Application No: **FP/185/10**

Sub-division of existing dwelling to create 1no. 2 storey 3bed dwelling & 1no. single storey 2 bed dwelling with parking
15 Limmer Lane Felpham

**Sub-division of existing dwelling to create 1no. 2 storey 3bed dwelling & 1no. single storey 2 bed dwelling with parking
15 Limmer Lane Felpham**

CLIENT SCL Ltd.			
PROJECT	Sub-division of existing dwelling in to two units of accommodation Nº 15 Limmer Lane, Felpham		
TITLE	FIRST FLOOR AND ROOF PLANS AS EXISTING AND PROPOSED (no changes)		
DATE	SCALE	DRAWN	CLIENT APPROVED
AUGUST 2010	1:50	BB	
Drawing Nº RTLL - 2010 - 003			Rev: A

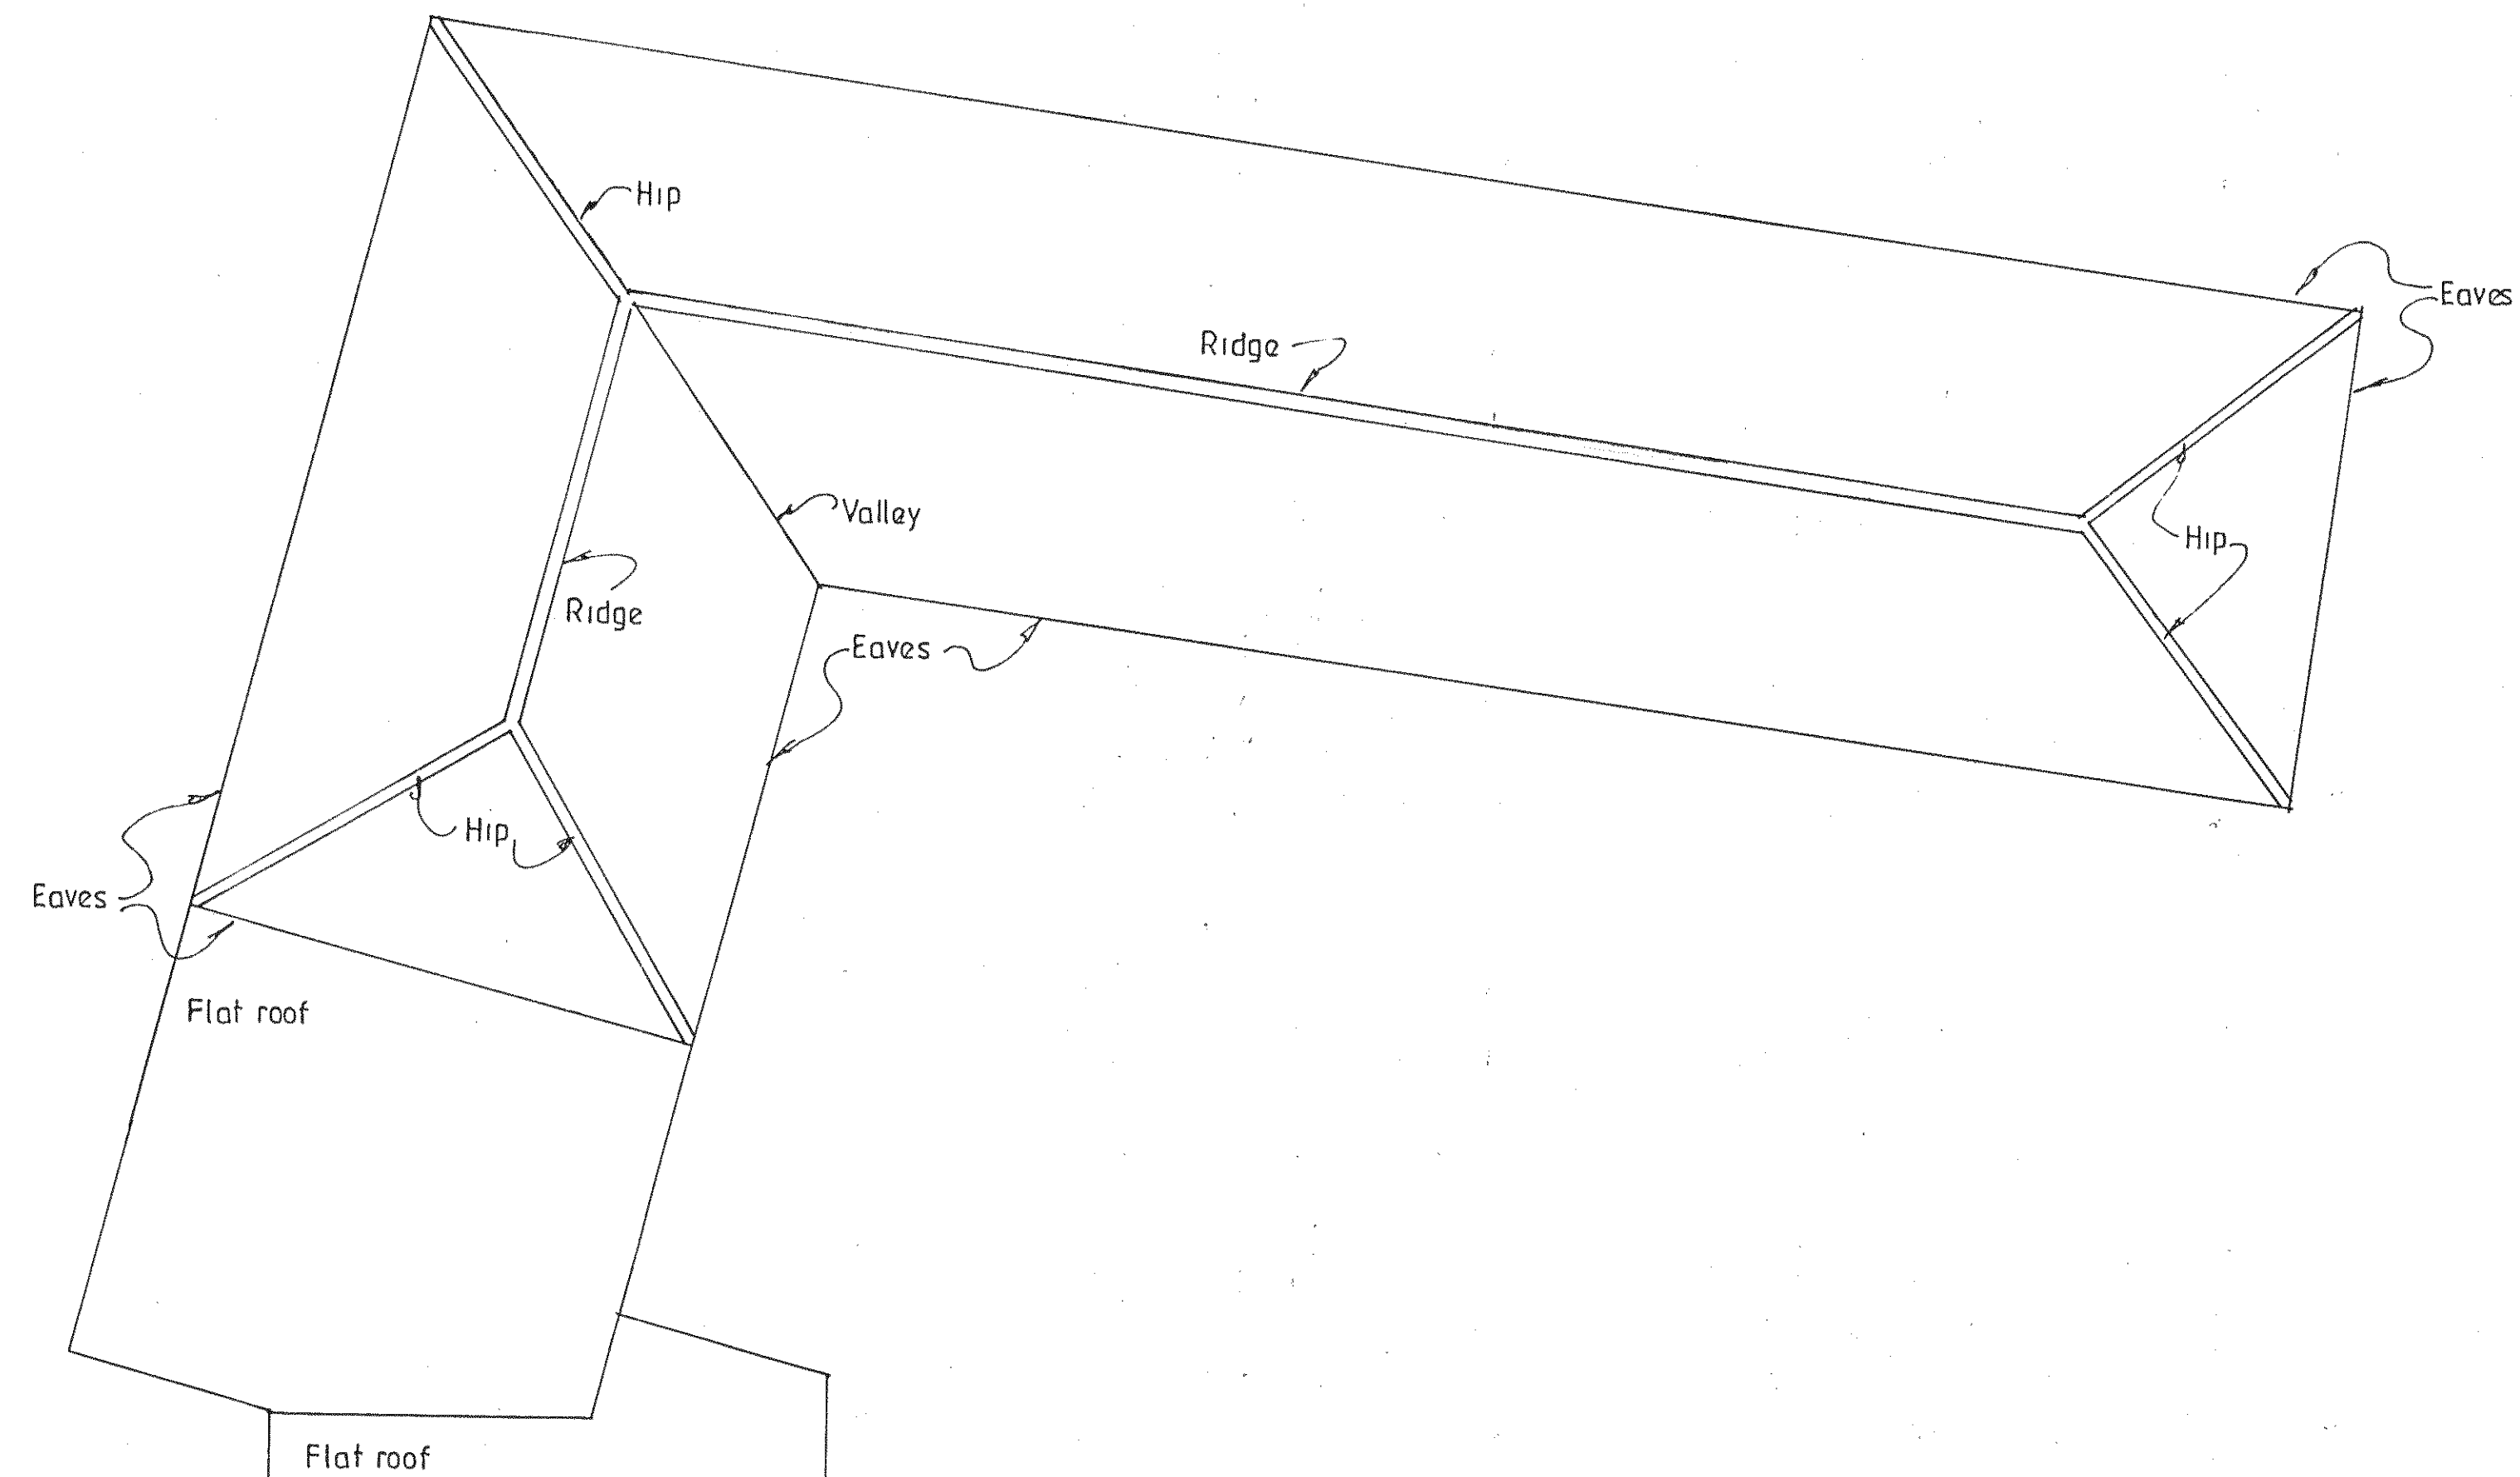
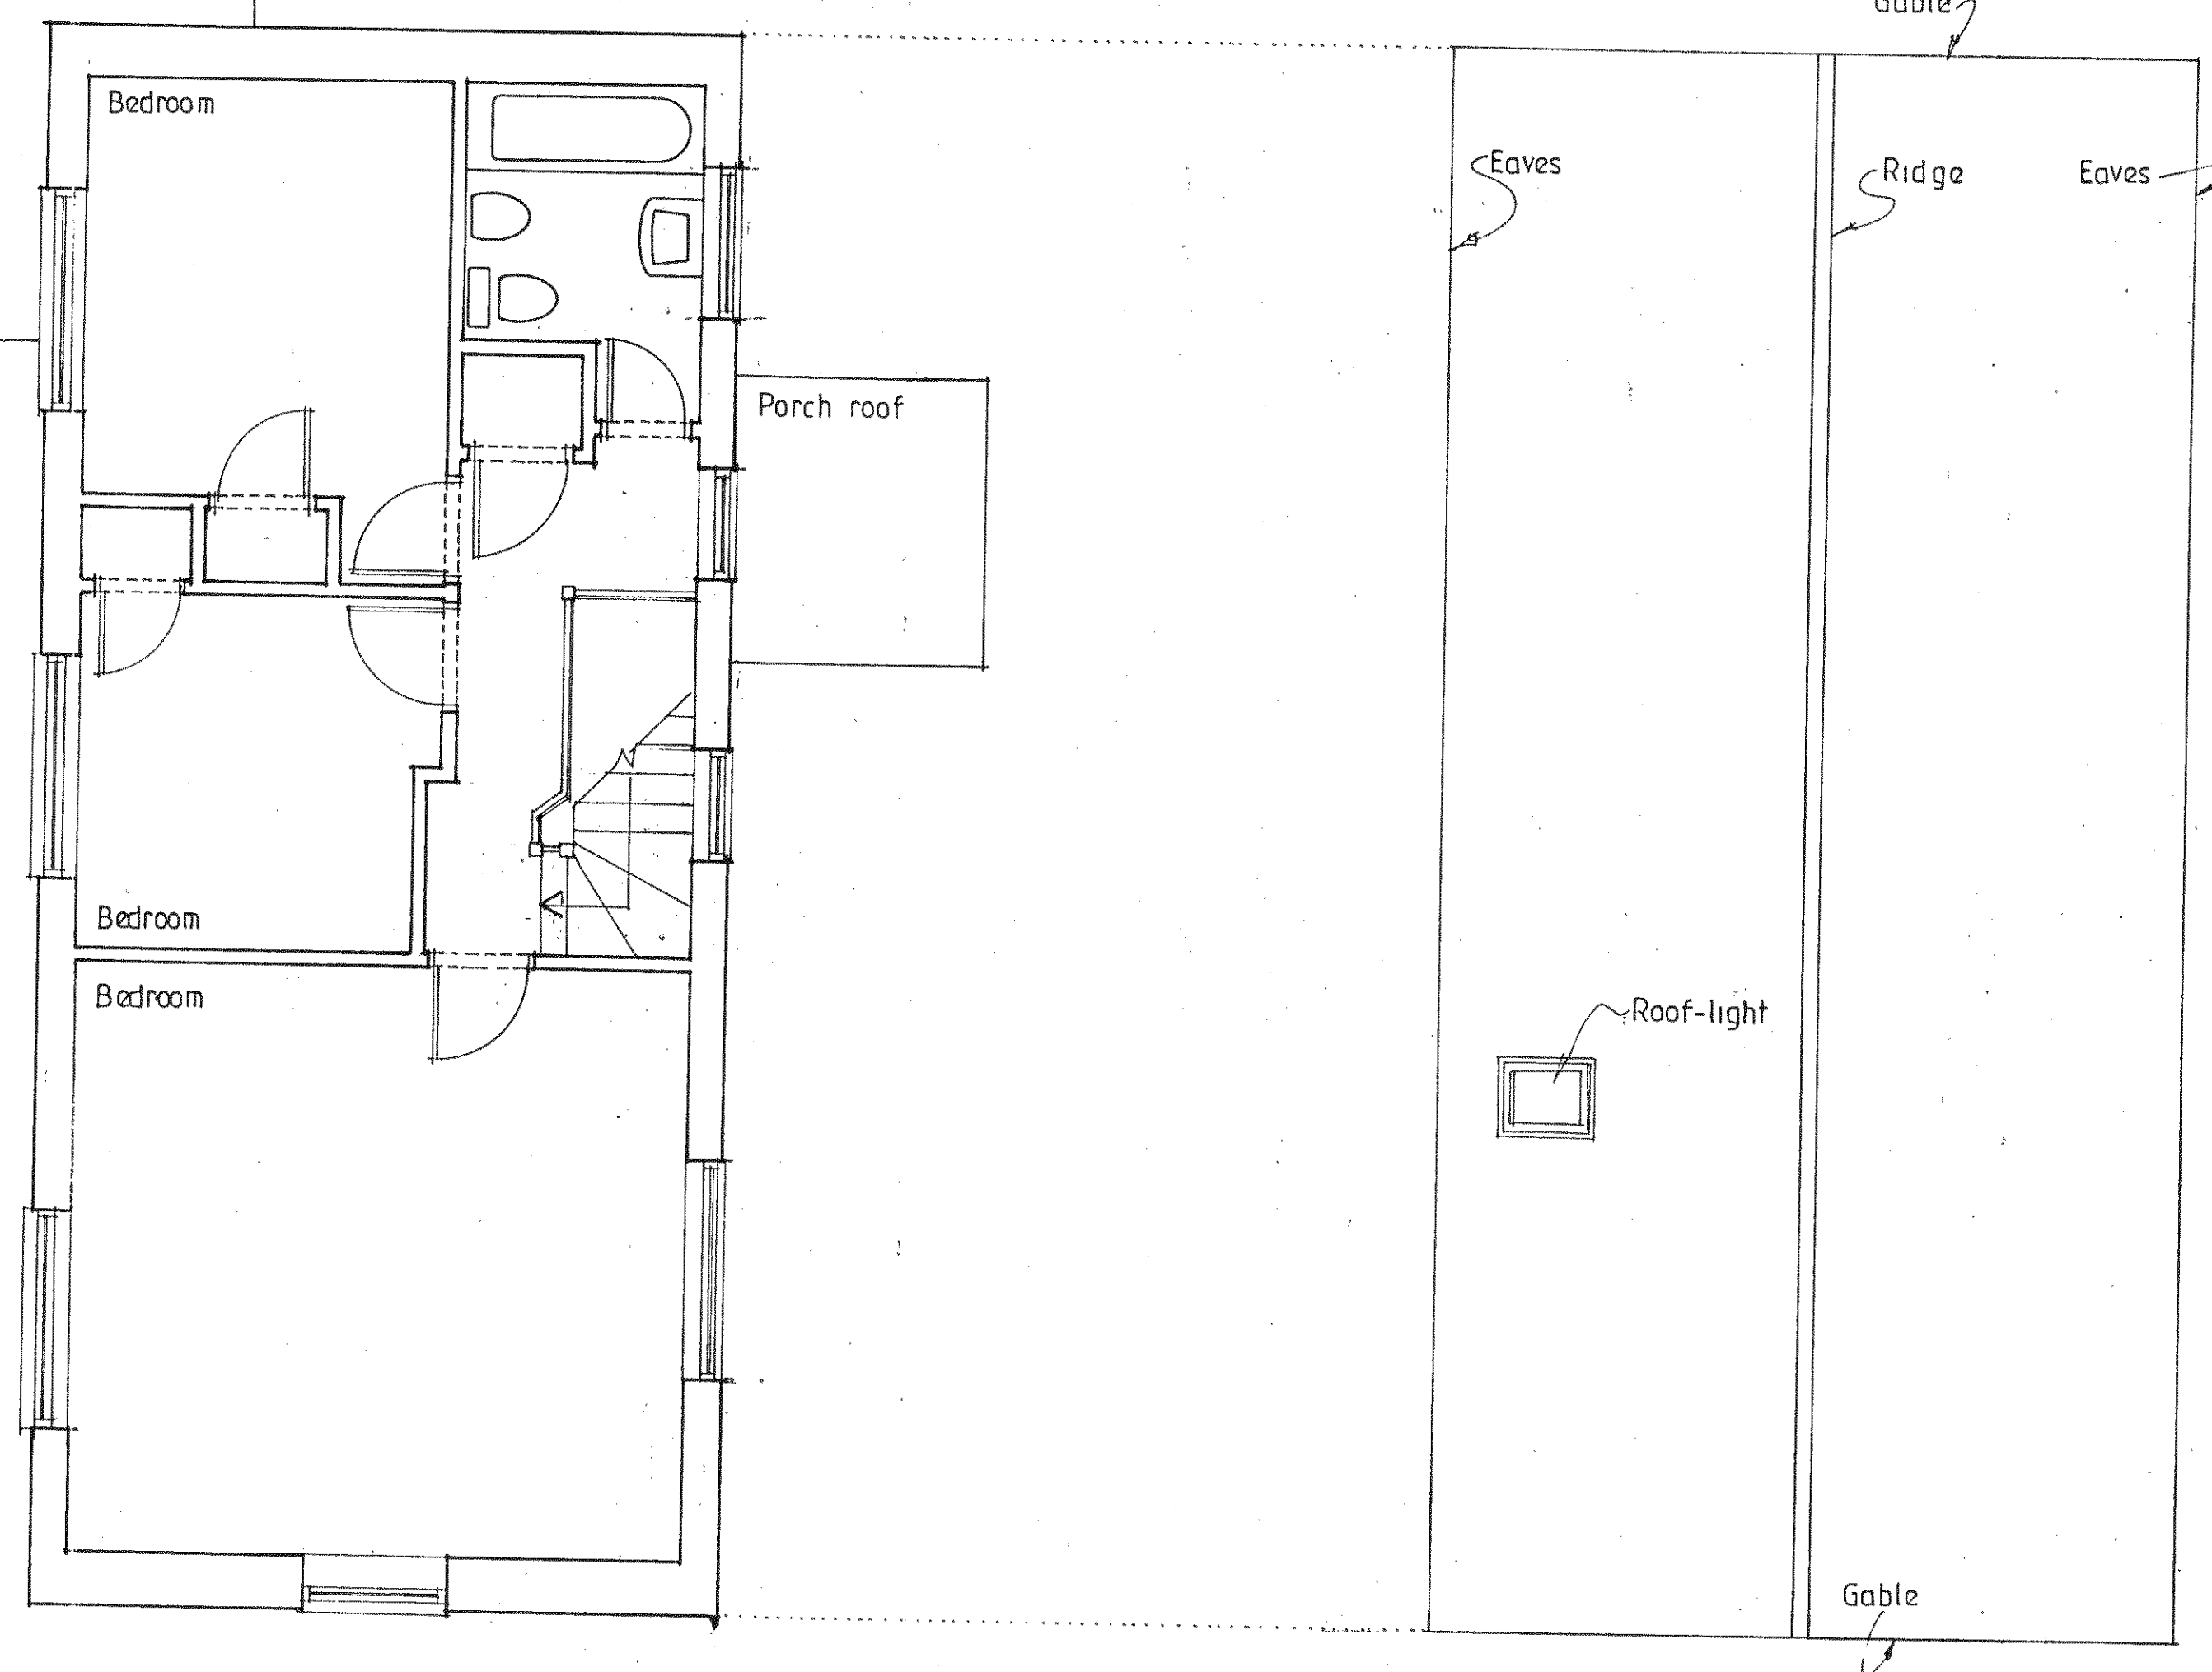
- The existing & proposed elevation facing west shows a roof light that is not shown on the floorplans/roofplan. Please amend accordingly.
- The existing & proposed elevation facing south shows a window on the ground floor which is not shown on the floor plans. Please amend accordingly.
- The existing & proposed elevation facing east does not show the porch detailed on the floor plans, and there is a circular window detailed on this elevation which is not shown on the floor plans. Please amend accordingly.

Drawing number RTLL-2010-003 Revision A now shows the existing roof-light on the roof plan over first floor level to correspond with the west elevation of the two storey dwelling.
